Rezoning Transportation Analysis

Petition Number: #2022-044

Date	Description
08-19-2022	First Review (AO)

RZ-1

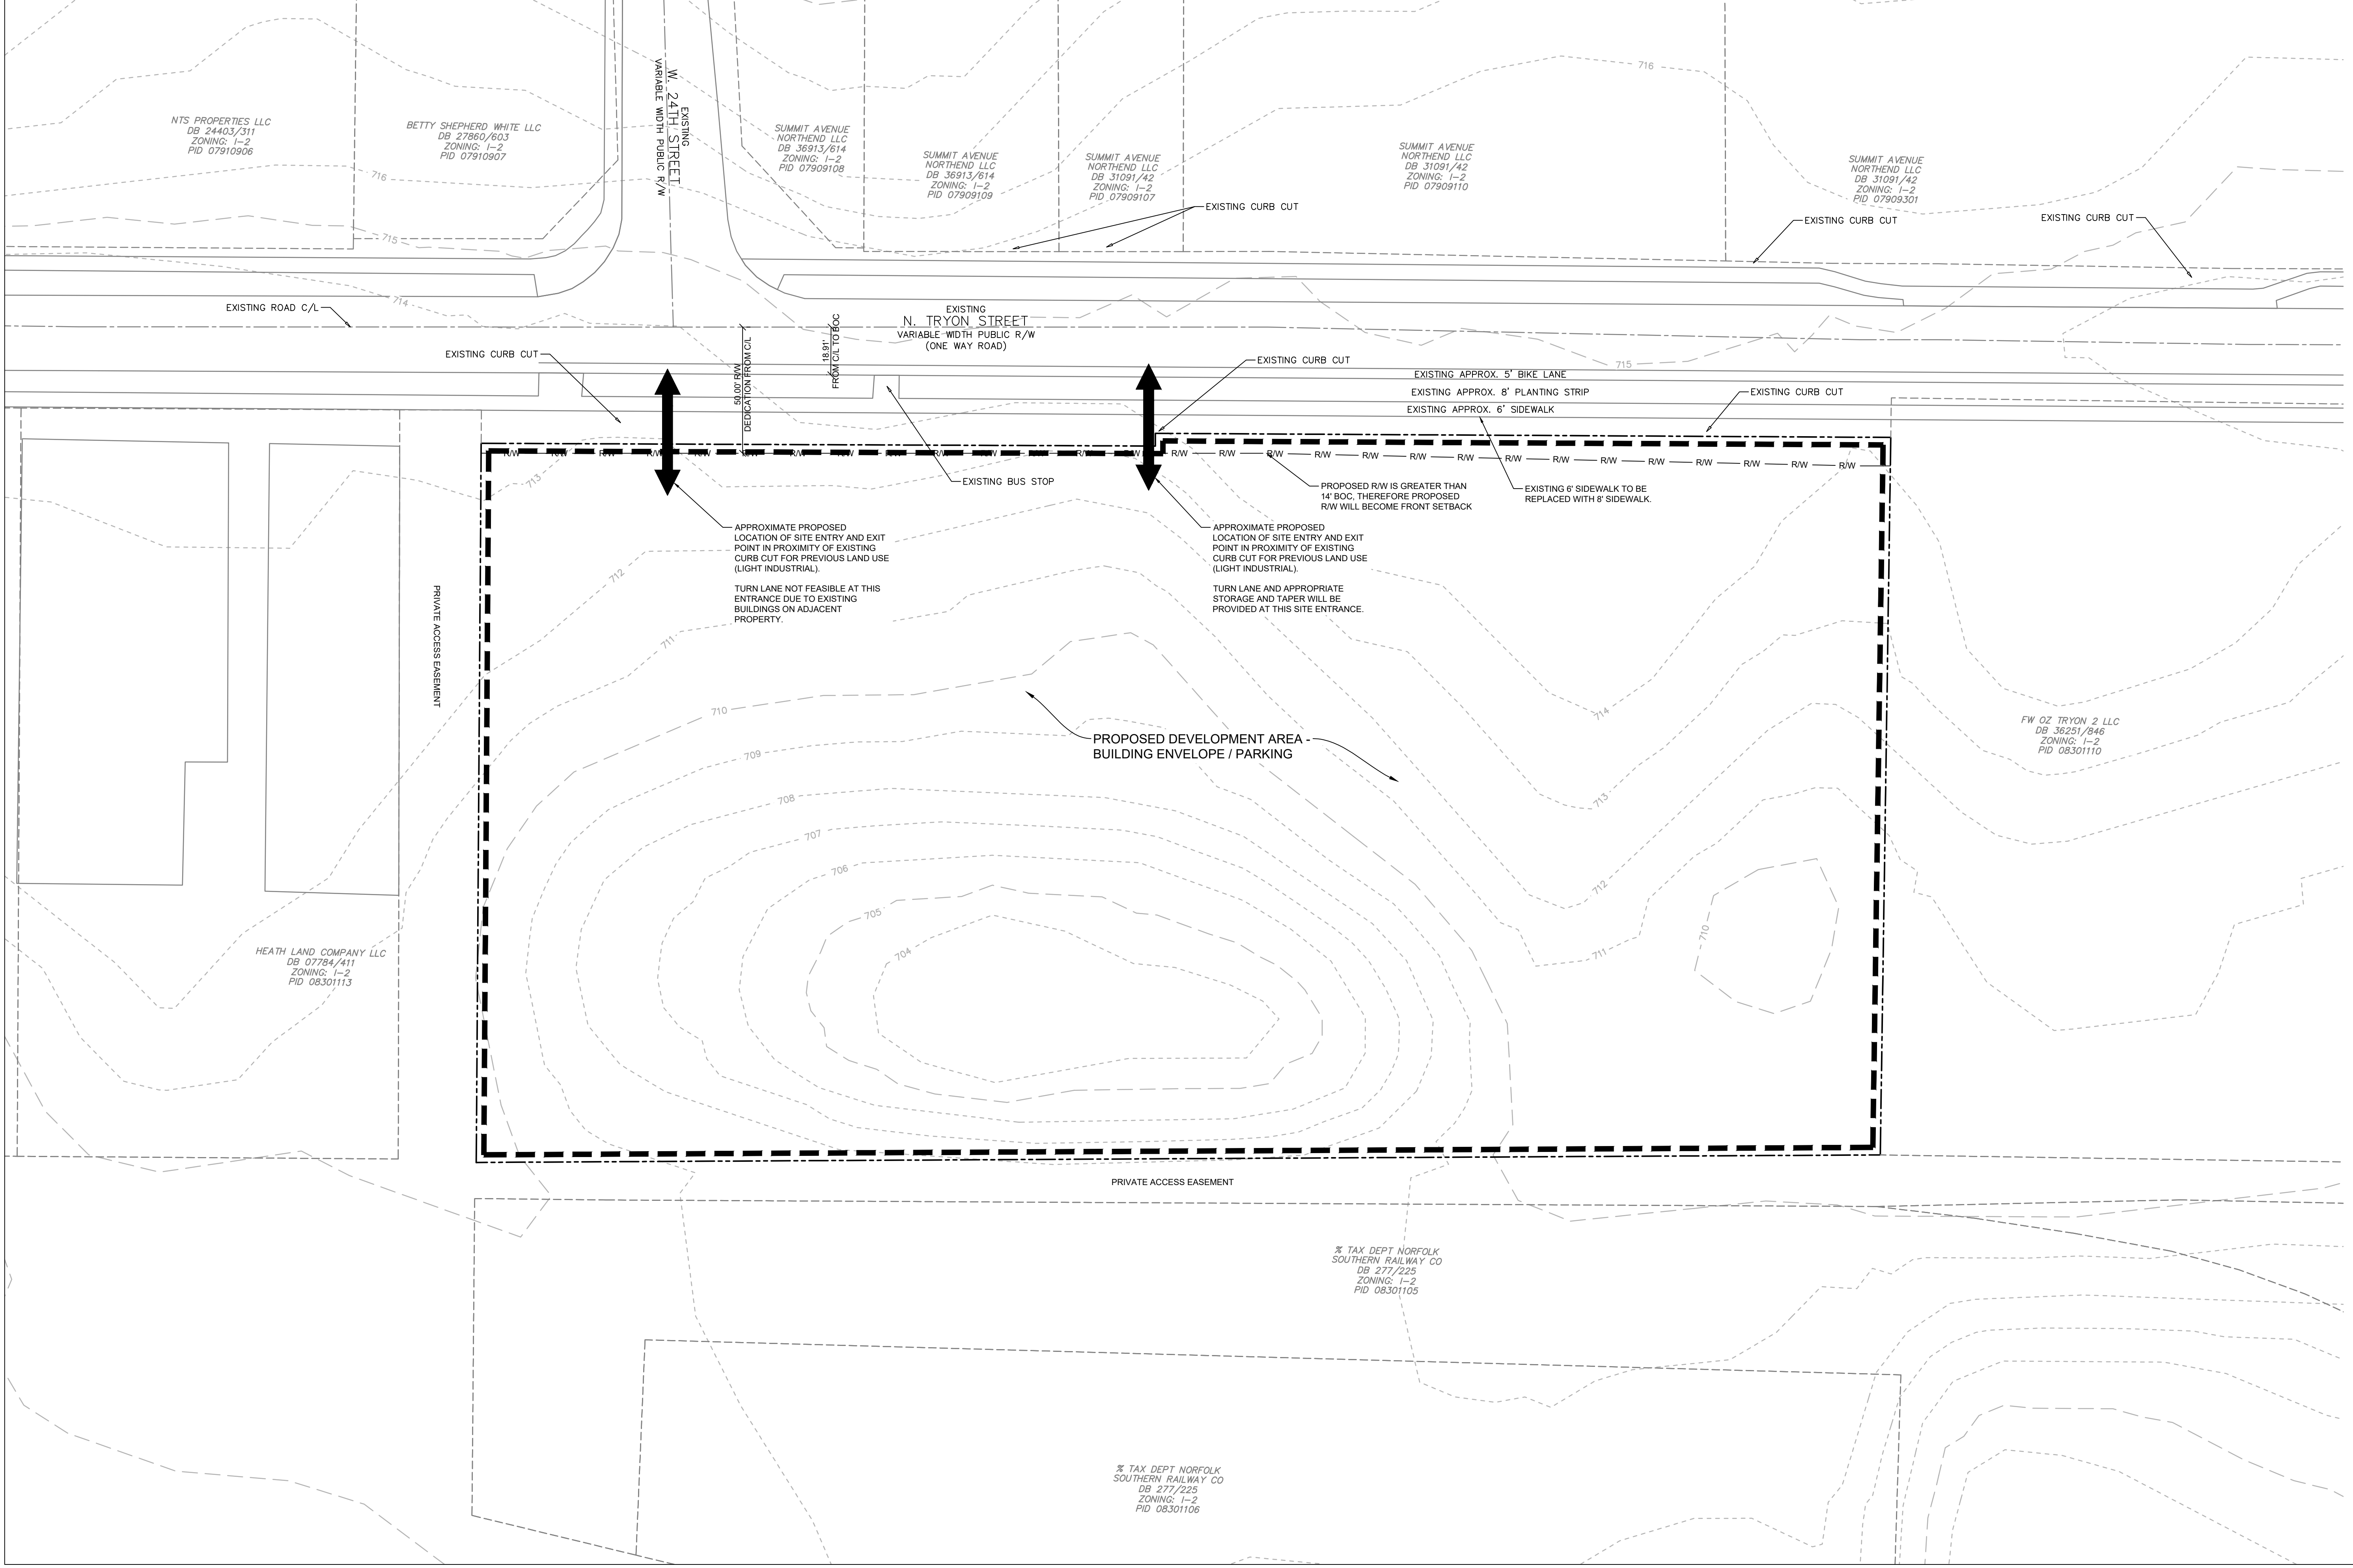
1. **Curblines:** The proposed zoning district has a setback measured from back of the existing or proposed future curblines.
 - a. **N Tryon St:** Future location of curb and gutter is in its existing location.

Label and dimension the curb and gutter from the centerline for each road on the site plan.

3. Revise site plan and conditional note(s) to commit to dedicate 50-feet of right-of-way from the road centerline as depicted on the site plan. The site plan shall label and dimension the right-of-way from the road centerline.

4. Revise site plan and conditional note(s) to commit to construct an 8-foot planting strip, and 8-foot sidewalk on N Tryon St per Chapter 19 / Chapter 20. The site plan shall label and dimension both items from the back of curb and gutter.

5. Add conditional note(s) to commit to maintaining existing 5-foot bike lane along N Tryon St to meet the City of Charlotte BIKE Policy. Site plan shows a 4-foot bike lane, this should be field verified and if it is 4-feet, a minimum 5-foot bike lane is to be provided.

6. Revise site plan and conditional note(s) to commit to constructing a right turn lane with 100' of storage and appropriate taper on N Tryon St at proposed access points per NCDOT requirements.

7. A site plan note(s) specifying dedication and fee simple conveyance of all rights-of-way to the City before the site's first building certificate of occupancy is issued as needed. CDOT requests rights-of-way set at 2' behind back of sidewalk where feasible.

8. A site plan note specifying that all transportation improvements will be approved and constructed before the site's first building certificate of occupancy is issued as needed. The petitioner may phase transportation improvements if said improvements and phasing are explicitly described in site plan notes.
